Wall at rear of 21 Hillingdon Rd

Mr Banks asked me to make comment on the rear boundary wall both in terms of structure as well as in respect to the style in conjunction to his main grade II listed home.

SIDE WALL EXTENSION - ELEVATION A

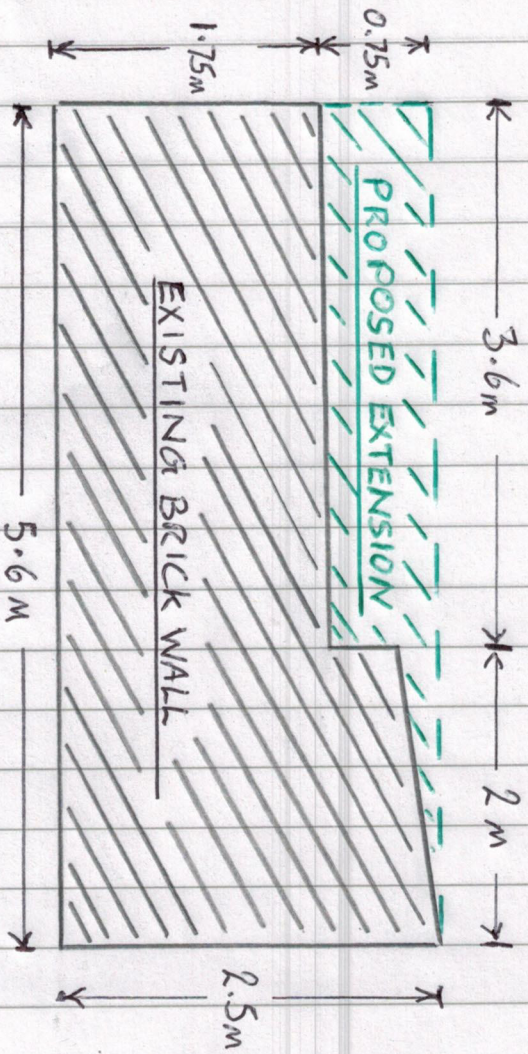
The wall is constructed of LBC commons and is built using a standard mortar mix. It is hard to establish the precise age of the wall but would appear to be between 40-60 years old. It is in reasonably good condition with the exception of the top course which has weathered over the years. Mr Banks said as part of the car port project this course will be removed and replaced with a new layer of matching bricks in addition to extending the walls height as per the plans. He further commented that the wall will be repointed and generally cleaned up. He also told me that the right hand 1m section of the wall was repaired/rebuilt in order to accommodate the electric roller garage gate installed in 1999/2000. Prior to this new section of wall going up his builder put in a new concrete footing of at least 2ft in depth. I can confirm that there has been no movement between this later section and the original wall.

The wall is true and is suffering from no cracks at all, nor any bulges of any kind. Furthermore there is no sign of any subsidence.

Upon closer inspection of the footings of the side wall I managed to establish that the brickwork below ground surface level extends to at least 2ft. The overall depth of the brickwork and indeed any concrete footing could not be established.

Given the walls good general condition it is highly likely that building up to the height outlined in his proposal will pose no significant issues or concerns to the fabric of the existing wall and sub base which has stood the test of both time and modification as described above.

It is capable of supporting several new courses of matching bricks.

It is so far removed from the actual main residence (35-40m) that the fact that the bricks differ from the stocks bricks used in the main house have no relation to the grade II listing. Indeed the LBC commons match his neighbour's wall at the very rear of his property but it is not possible to comment further as both of these walls were constructed prior to the current occupants.
